Condition 11- Surface Water Drainage Design

Application No: CM/11/21/DOC
Registered: 5th March 2021
Site Address: Scyld Horsemere Green Lane Climping BN17 5QZ
Description of Works: Approval of details reserved by condition imposed under CM/21/19/PL relating to conditions 11-surface water drainage scheme, 12-discharge of flows to water courses or for the culverting, diversion, infilling or obstruction of any water course on or adjacent to site & 13-maintenance and management of surface water drainage system.

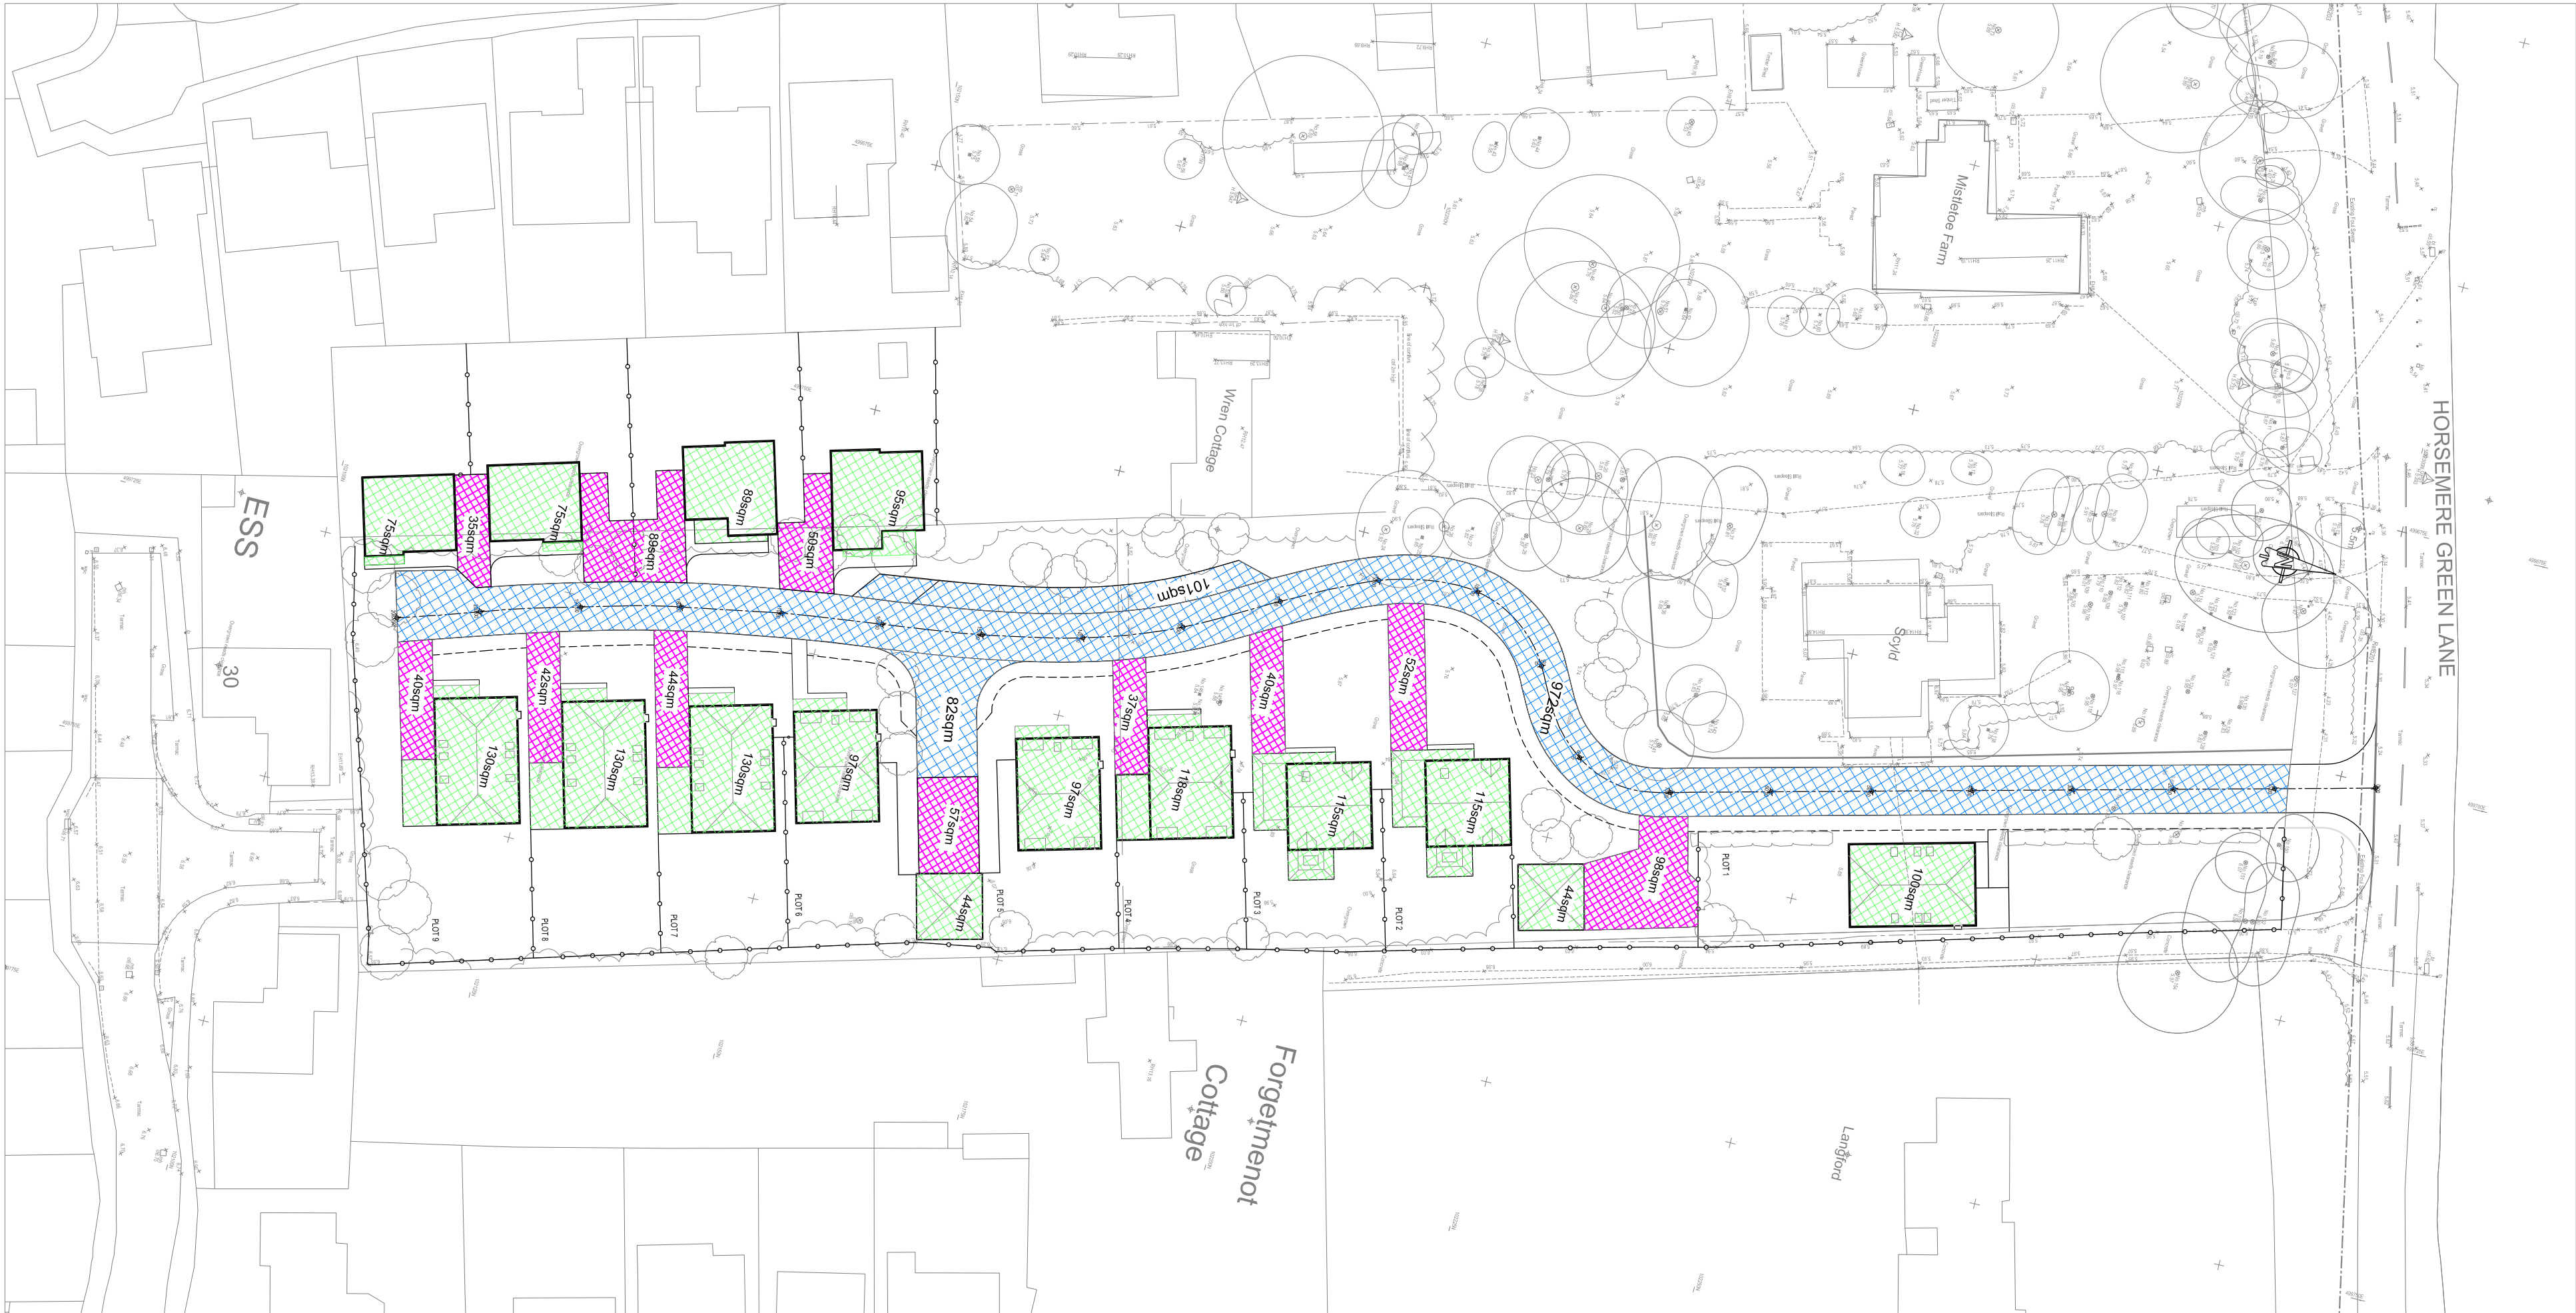
2. The impermeable areas plan appears to use an old layout, not the latest layout as approved under CM/55/20/PL. Please provide an updated impermeable areas plan. Updated plan attached to be read alongside the new calculations / drainage modelling.

2. The impermeable areas plan appears to use an old layout, not the latest layout as approved under CM/55/20/PL. Please provide an updated impermeable areas plan. Updated plan attached to be read alongside the new calculations / drainage modelling. *Okay, point closed.*

DRAINAGE GA

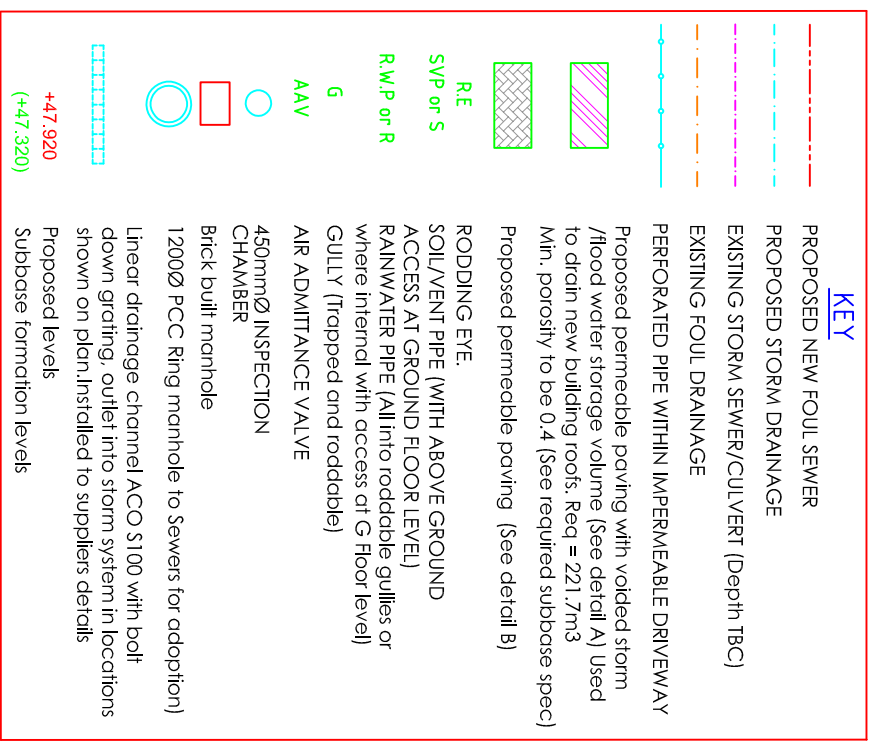
4. Please detail finish and formation levels of permeable paving on plan. These are shown in the detailed sections but have also been added to the plan. *Please detail on driveways.*

6. Please detail all pipe diameters and falls on plan. Plan updated. *Please detail pipes in permeable paving driveways.*

4. Please detail finish and formation levels of permeable paving on plan. These are shown in the detailed sections but have also been added to the plan.

6. Please detail all pipe diameters and falls on plan. Plan updated
7. No connections are shown to/ from the permeable car park areas. We have now shown a connection into the storm drainage system.

DRAINAGE DETAILS (2 of 2)

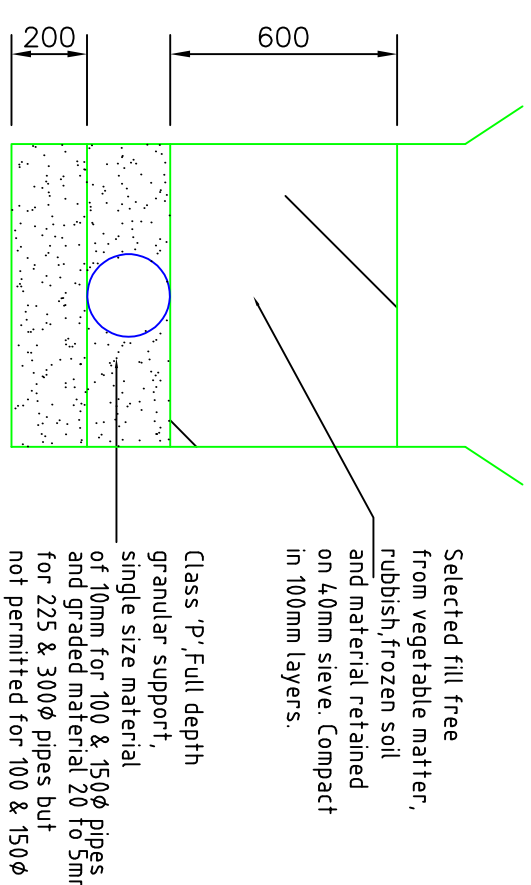
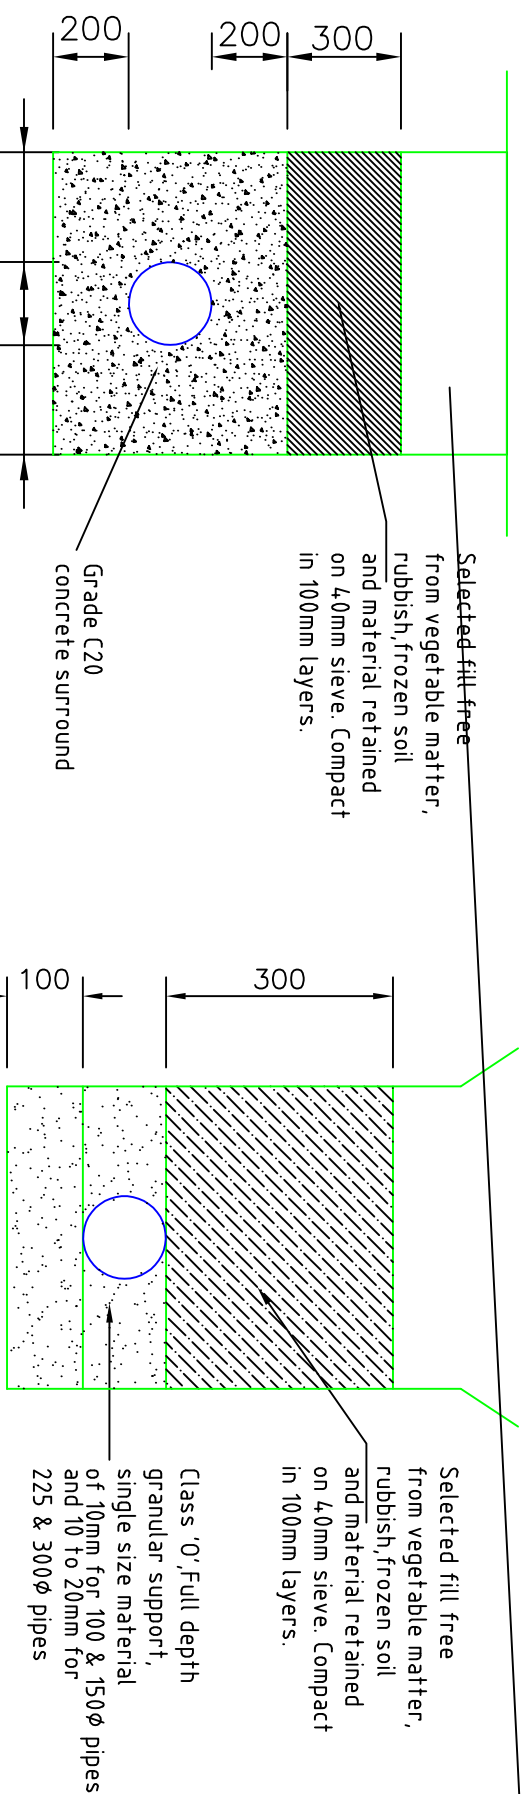
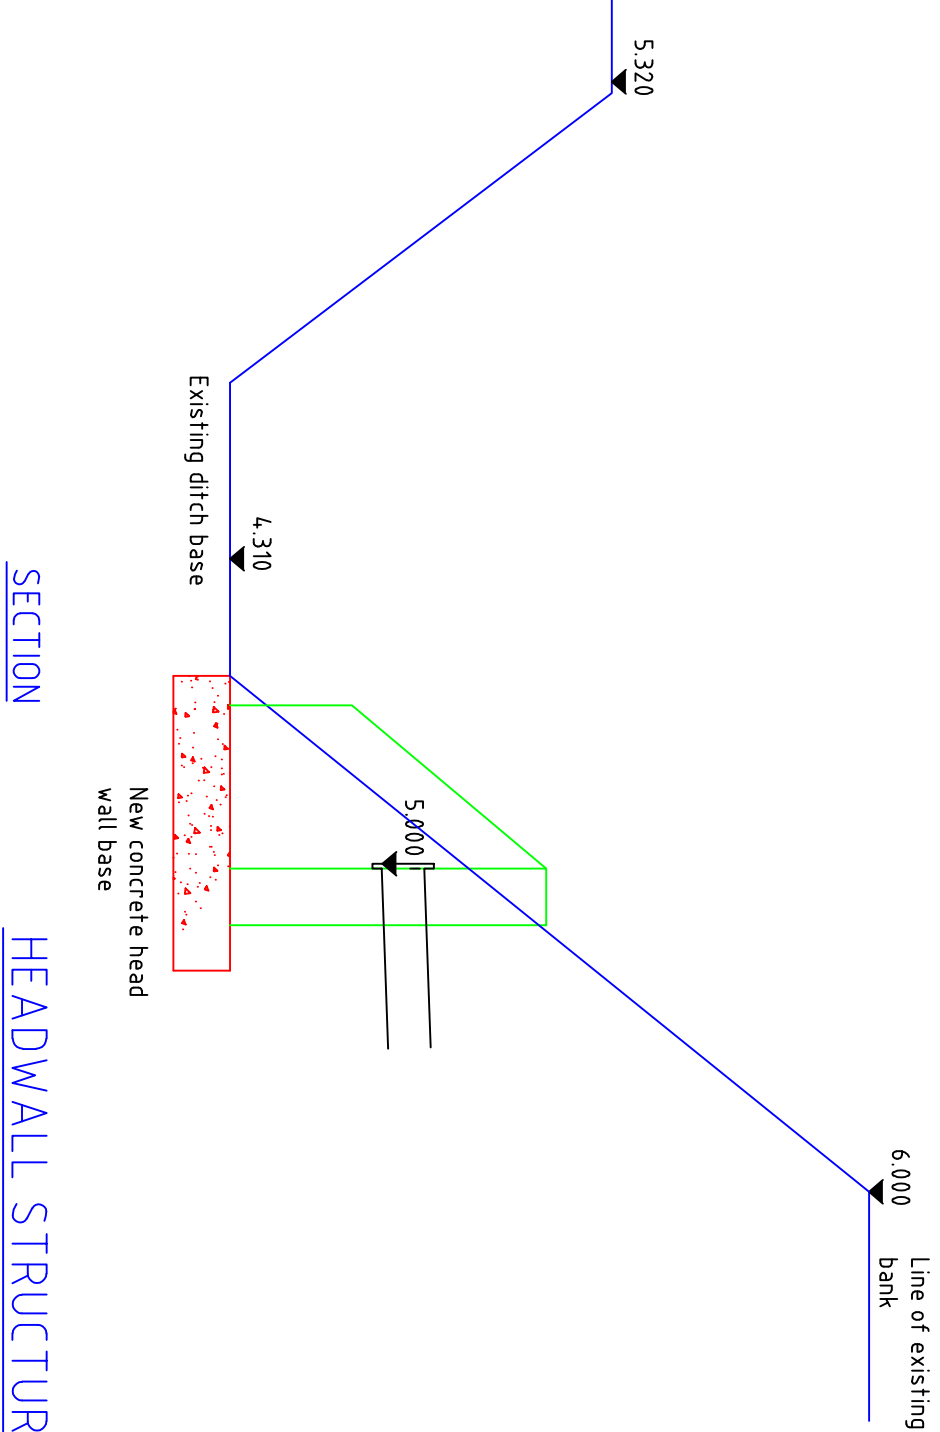
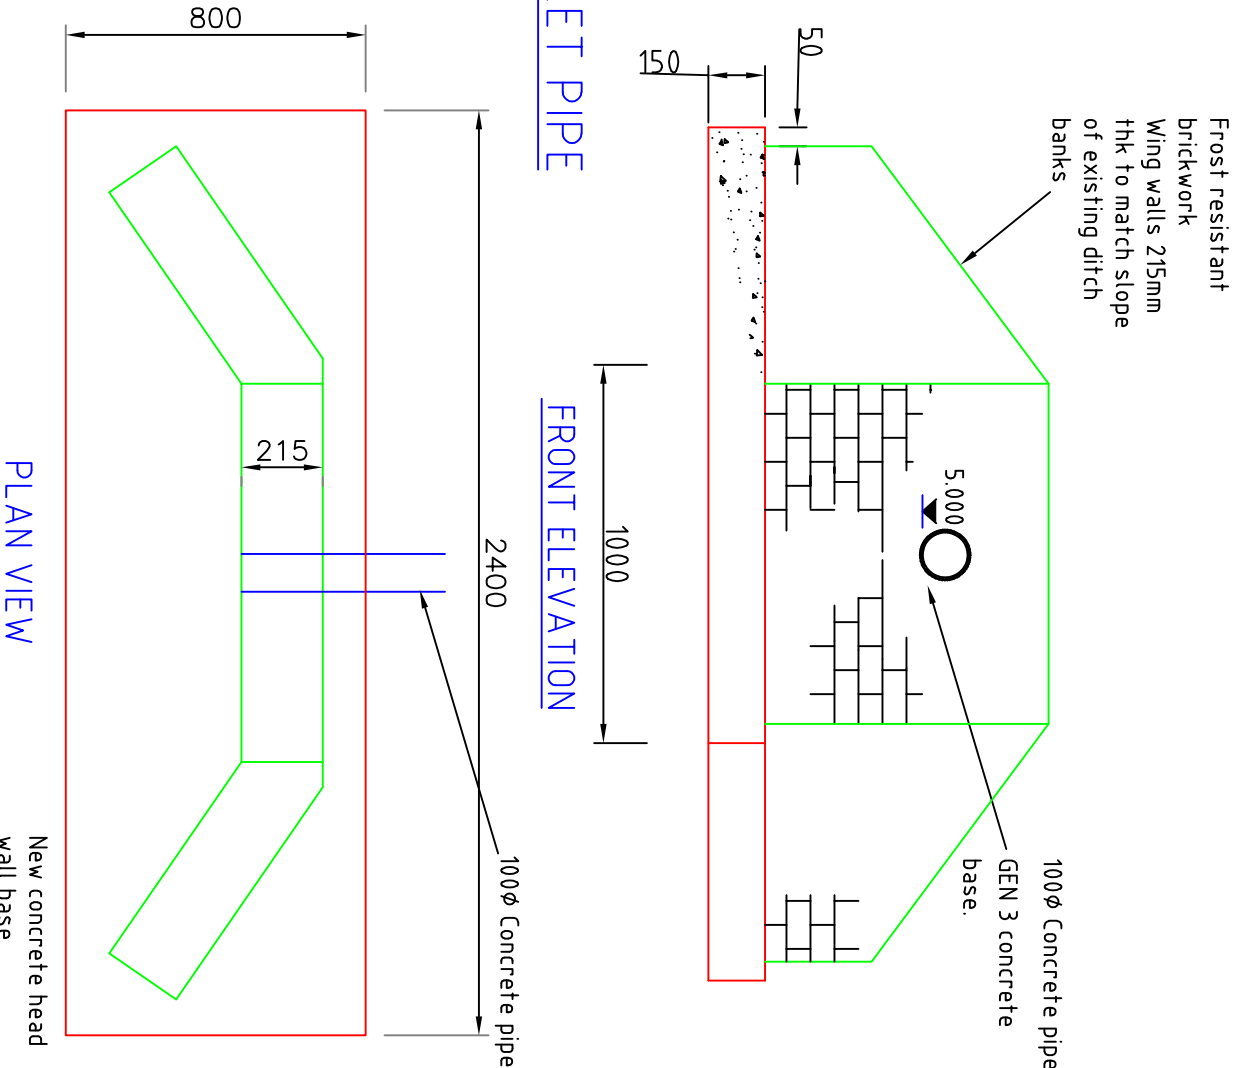
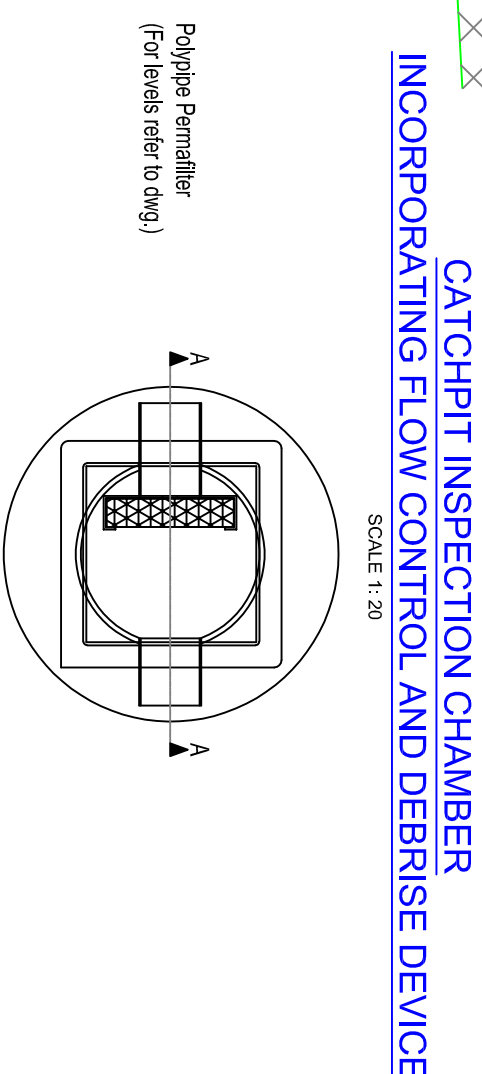
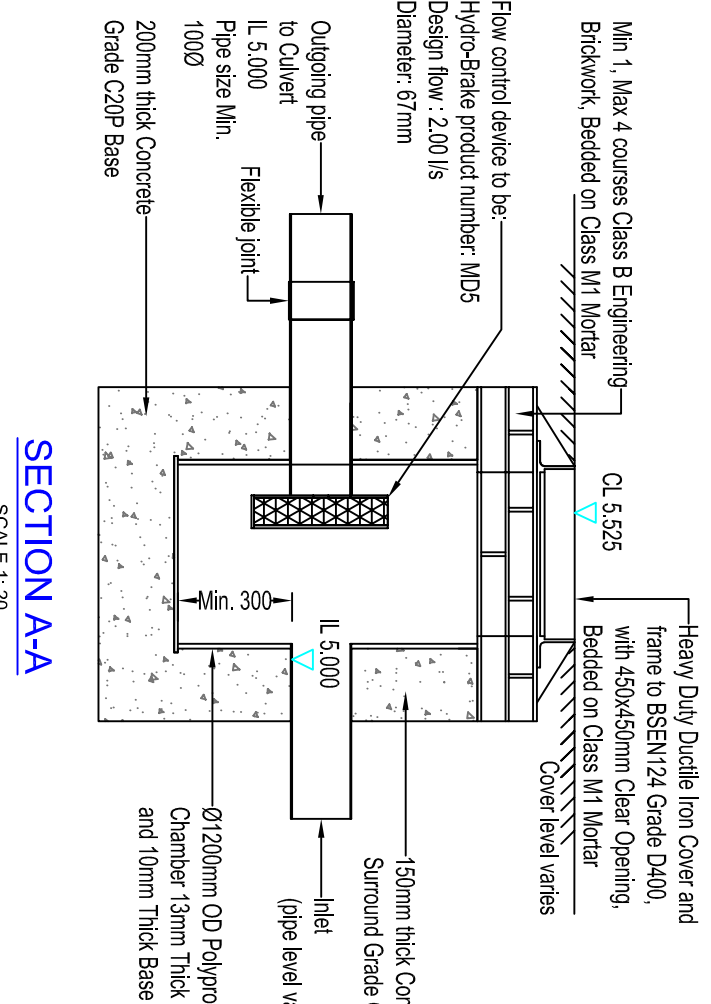
7. No connections are shown to/ from the permeable car park areas. We have now shown a connection into the storm drainage system.
8. Please provide site specific construction detail drawings of the proposed headwall, this should include a plan and full cross section through the ditch. All headwall drawings should indicate existing bed level, and top of bank level. Detail updated. *Two sets of drainage details sheet 2 have been provided, please confirm which version should be reviewed.*

8. Please provide site specific construction detail drawings of the proposed headwall, this should include a plan and full cross section through the ditch. All headwall drawings should indicate existing bed level, and top of bank level. Detail updated.
